## NE18: Natural England Comments on Cumulative Impact Assessment of Soils and Agricultural Land

**Chapter Reviewed: Volume 6.0: Environmental Statement [EN010159] Volume 2: Aspect Chapters Chapter 18: Cumulative Effects**

**Chapter Reviewed: Volume 6.0 Environmental Statement [EN010159] Volume 3: Technical Appendices Supporting ES Volume 2 Appendix 18.3 Summary of Other Developments included within the Cumulative BMV Assessment February 2025 Document Reference: EN010159/APP/6.21**

Client:
One Earth Solar Farm Ltd

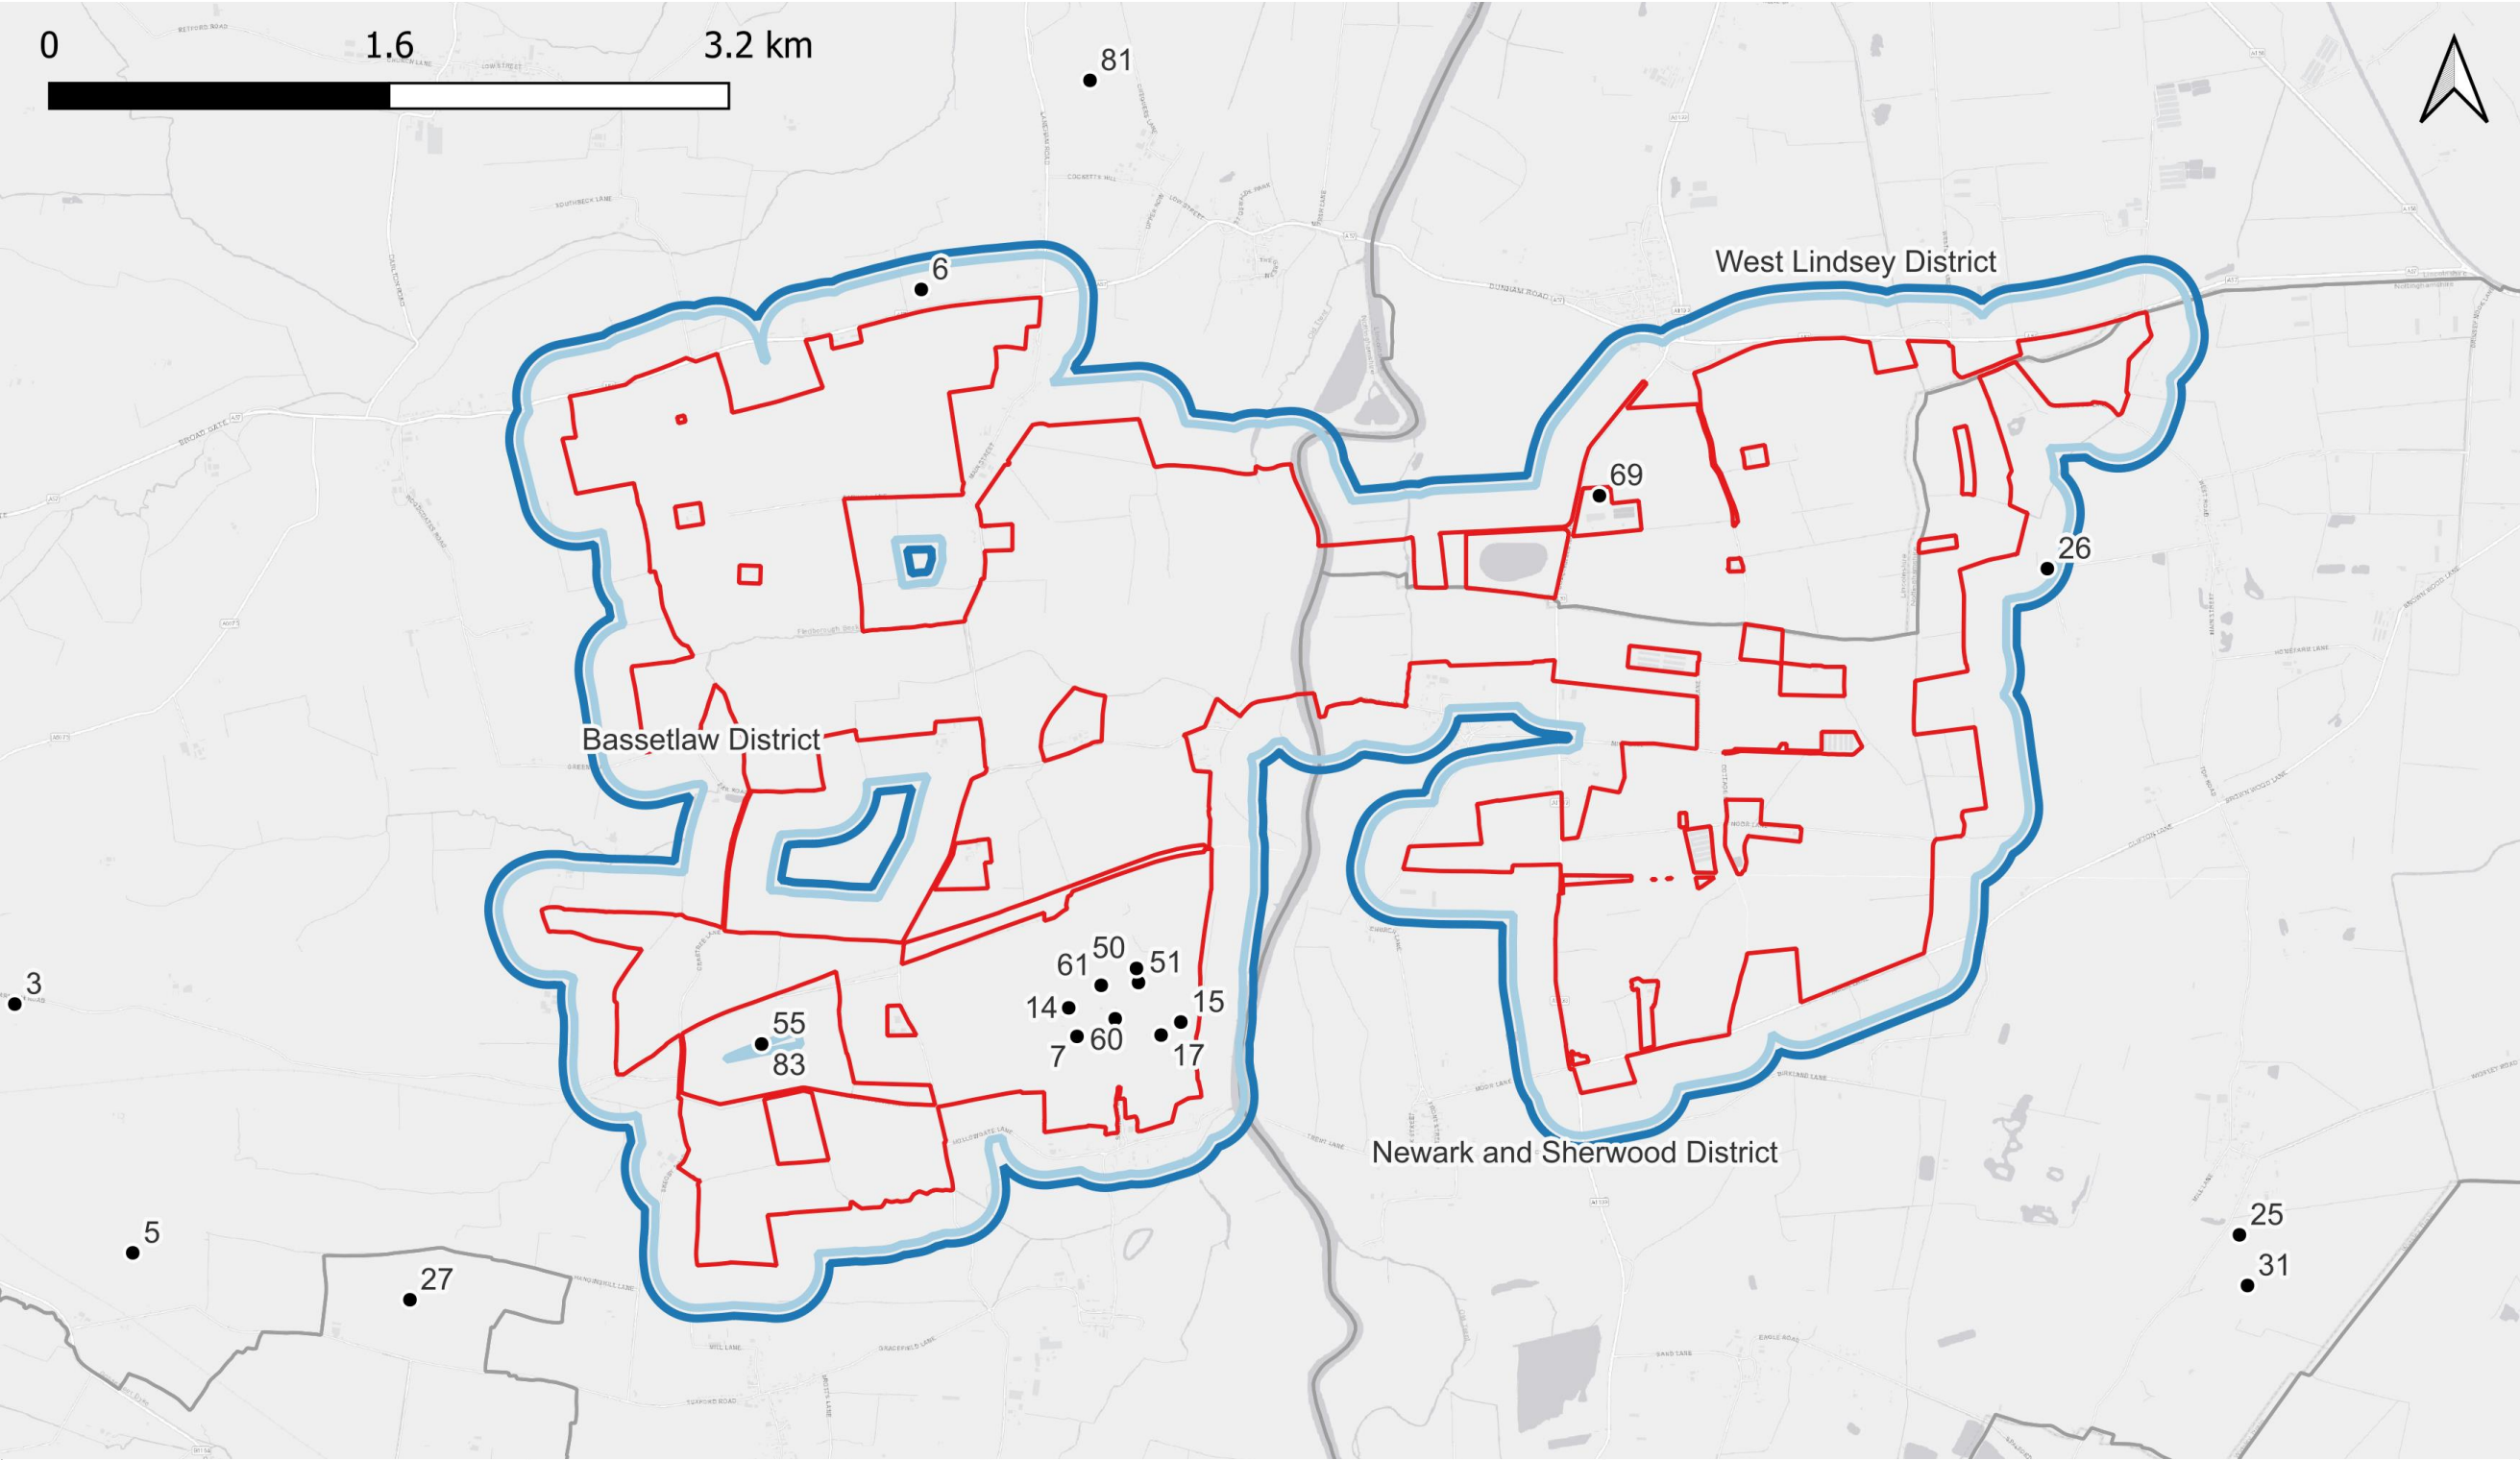
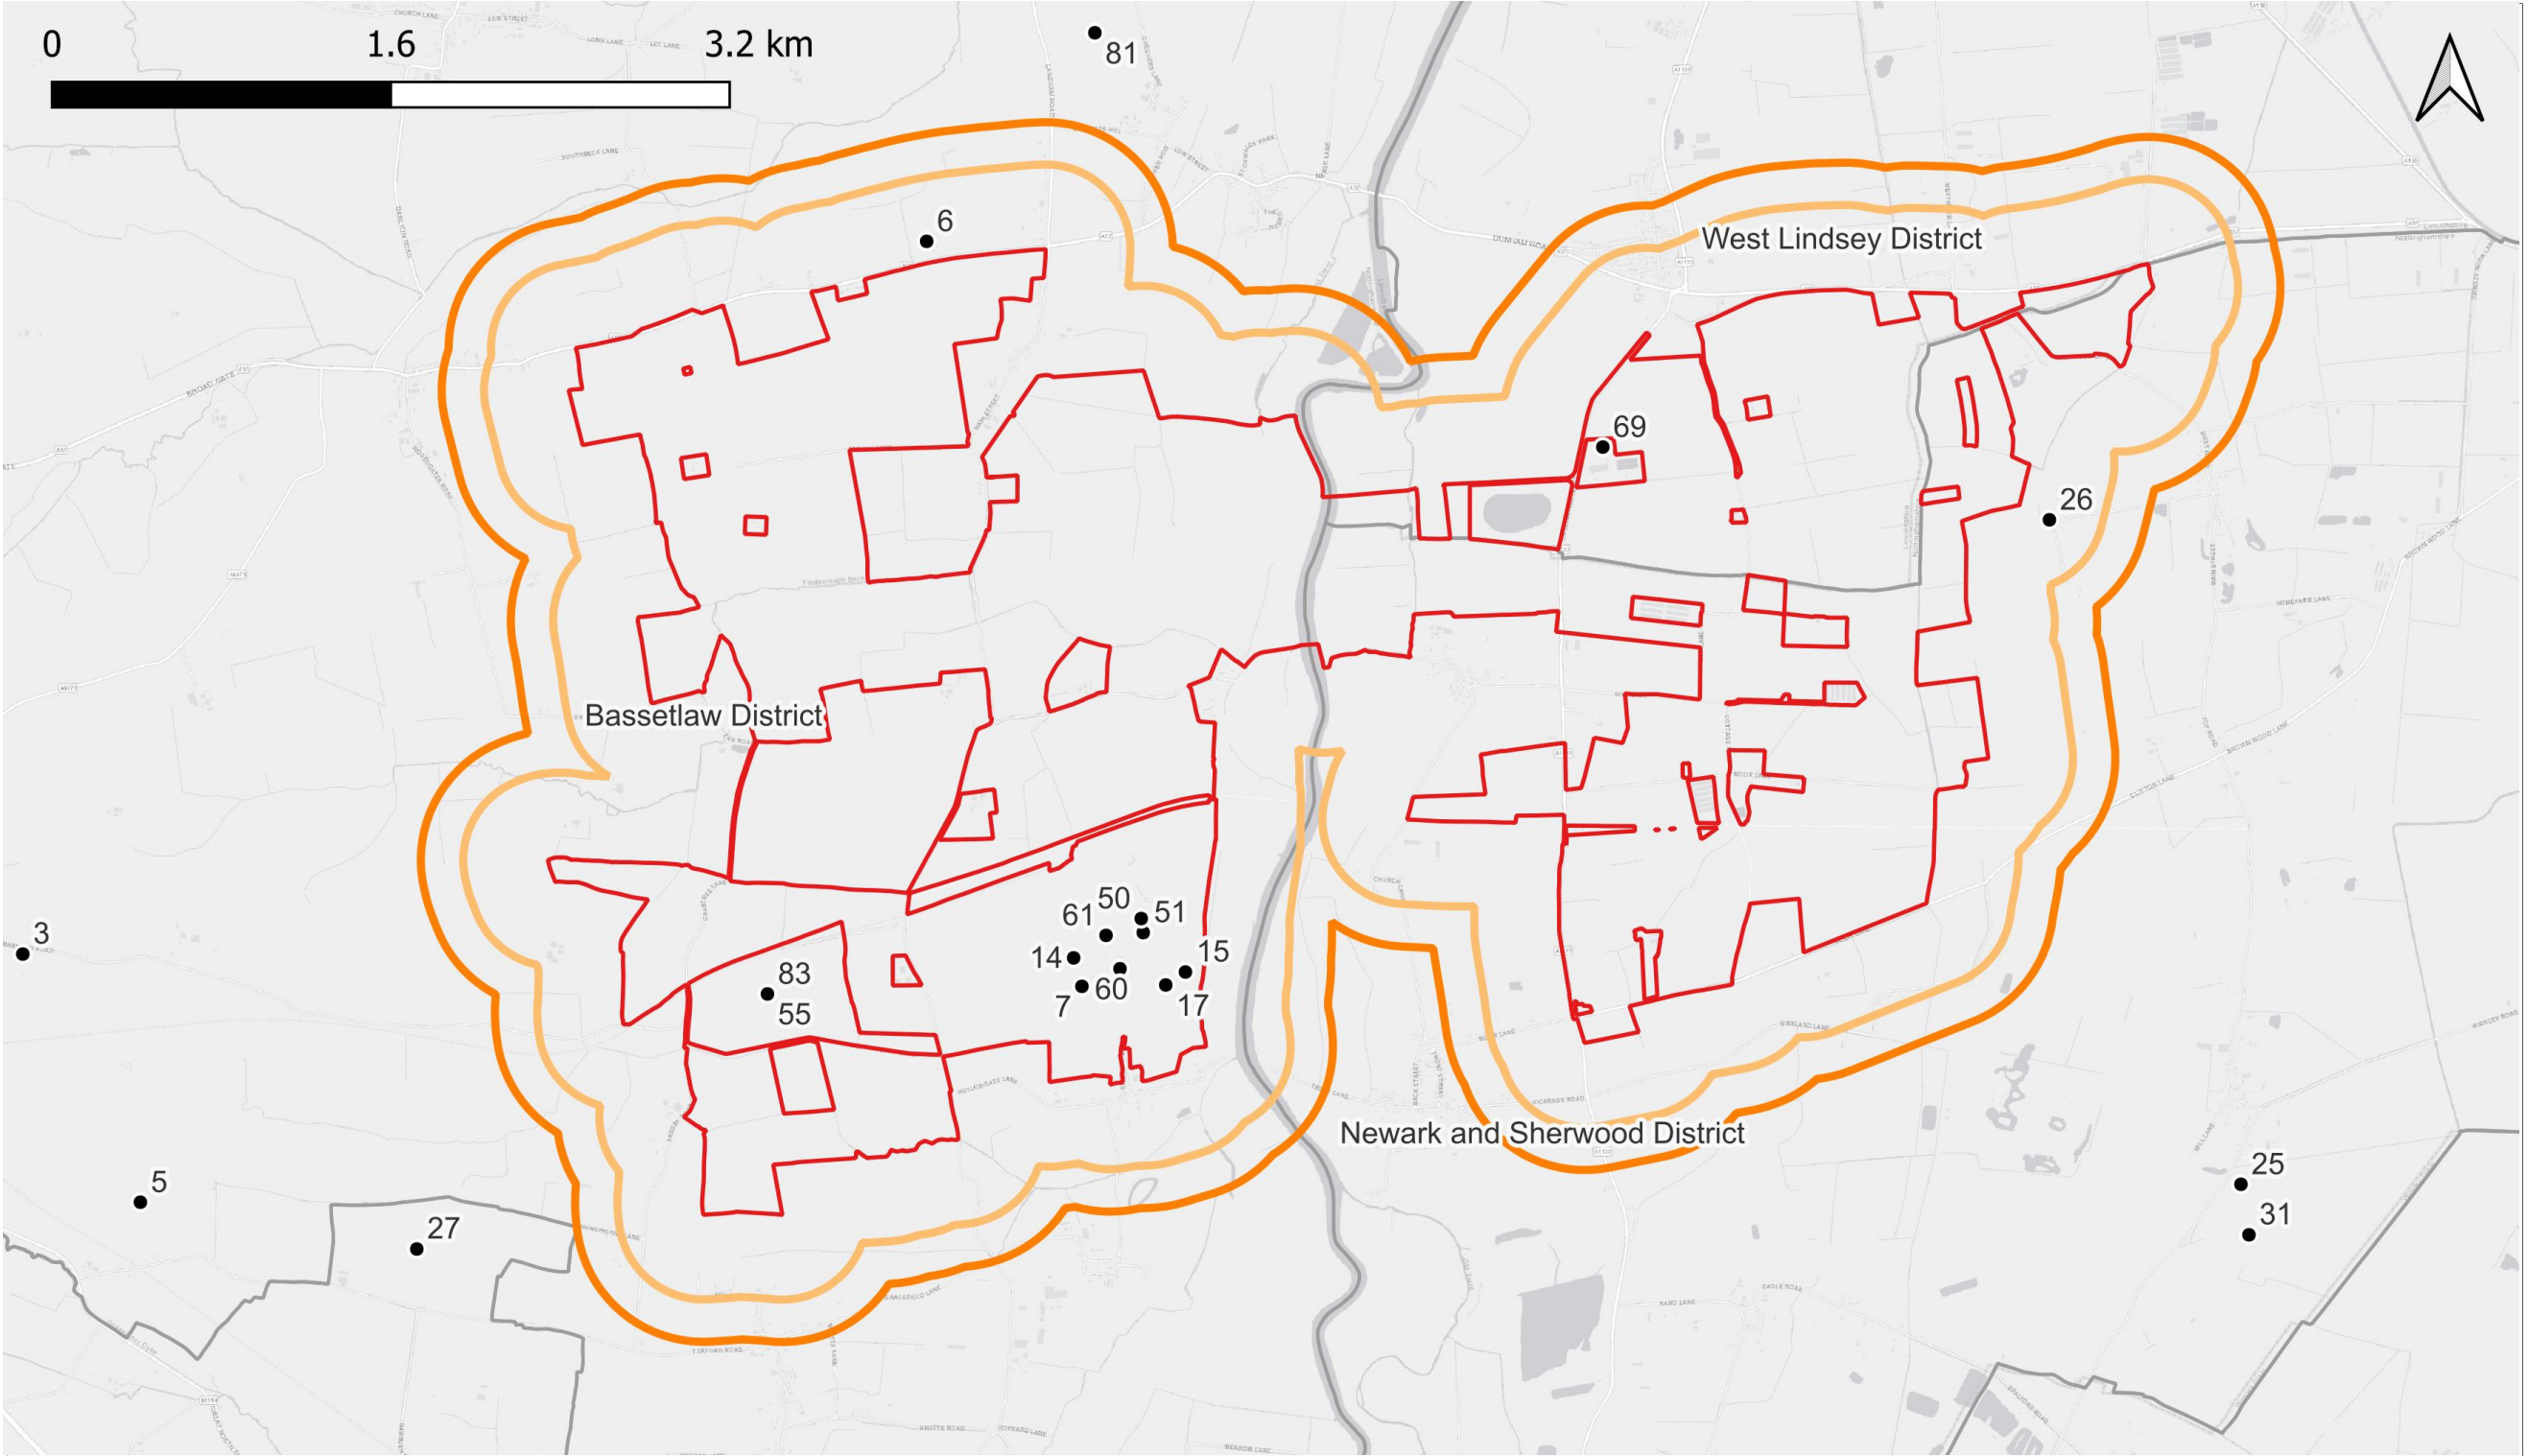
**18.3.19** Natural England are broadly satisfied with the regional Zol and the information provided within ES Volume 3, Figures 18.1 to 18.8 [EN010159/APP/6.20] for a regional cumulative assessment, however we refer the applicant back to the comment above (table 18.2)
